The Bridleway Route from Point 1 follows Burbage Common Road to the Bridleway within Burbage Common, this then connects along the existing Bridleway Route to the proposed Bridleway within the development site.

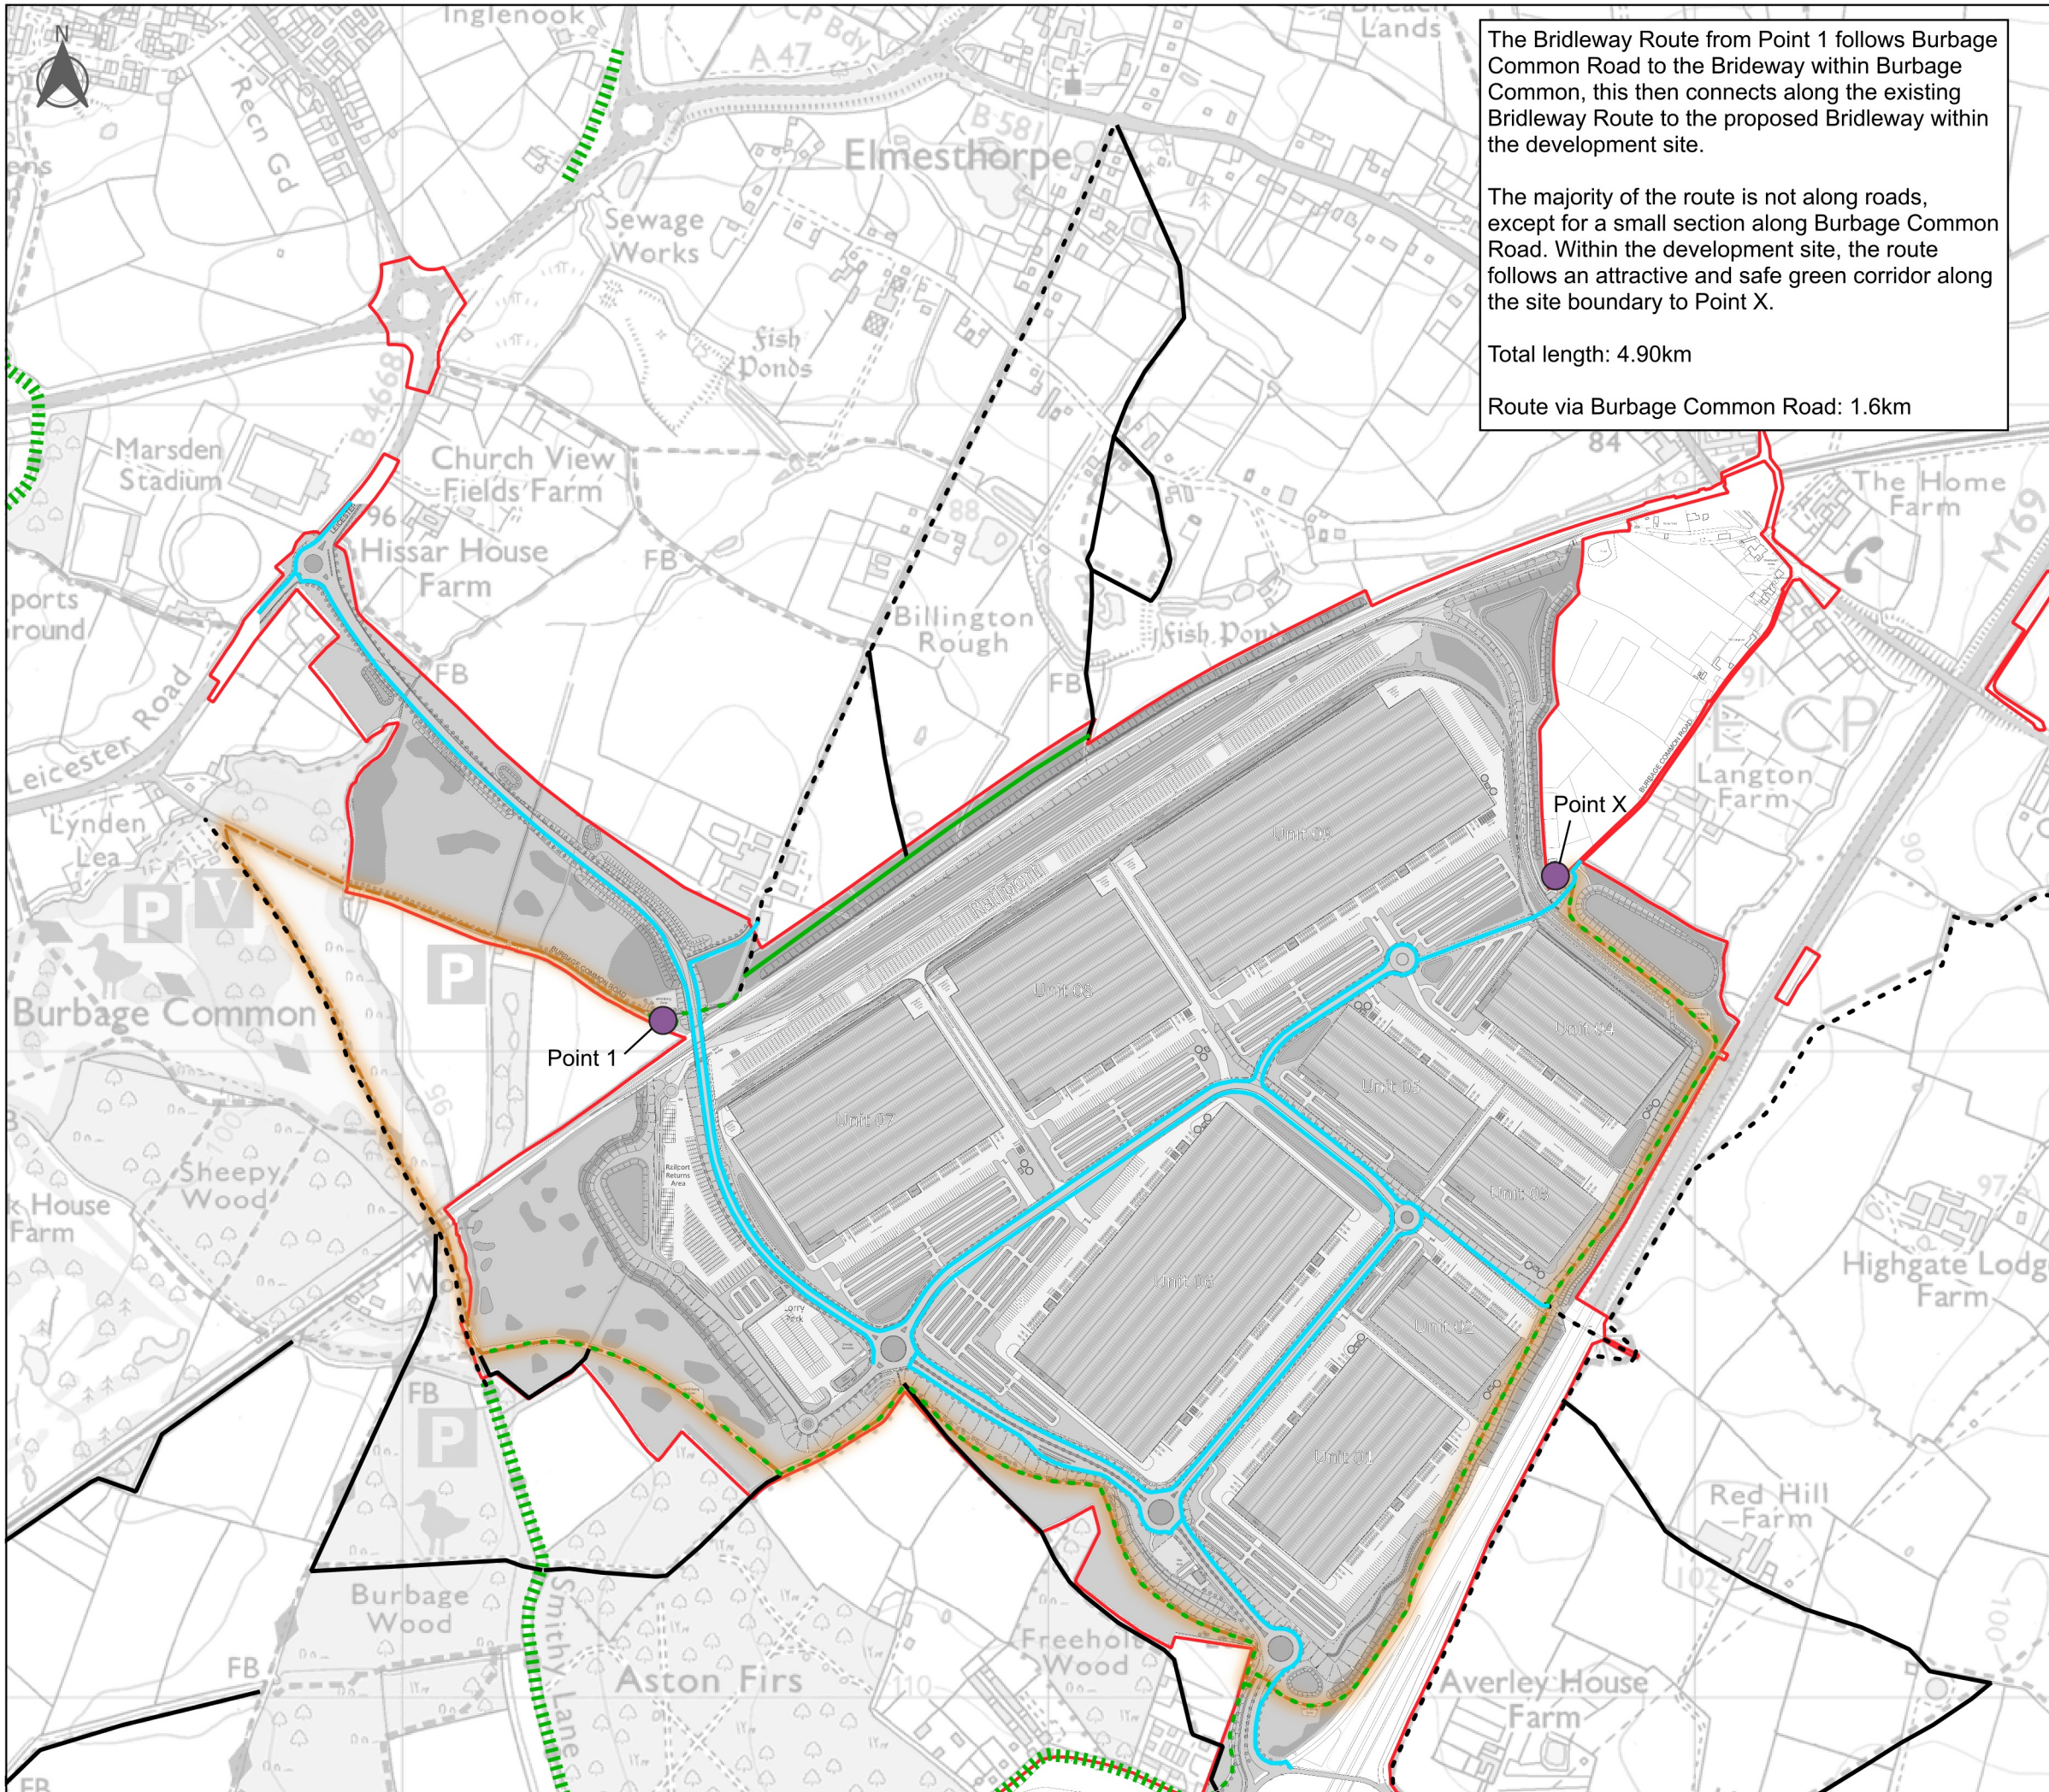
- The PROW(s) that currently link Elmesthorpe to Burbage Common SSSI (including Elmesthorpe Plantation) have been replaced by much more industrial routes. A place that was once on our doorstep now feels to have been cut off from us.
- There is a significant cluster of existing RFIs in the area, most of which are considered under utilised. It does not appear to have been researched or stress-tested that fully utilising these areas may be a more appropriate option.
- When comparing the amount of freight trains allegedly designed to use the RFI to the numbers of HGVs movements, it is very clear that this is a HGV transport hub, with rail being a secondary function (if at all). This is a warehousing application disguised as an NSIP.
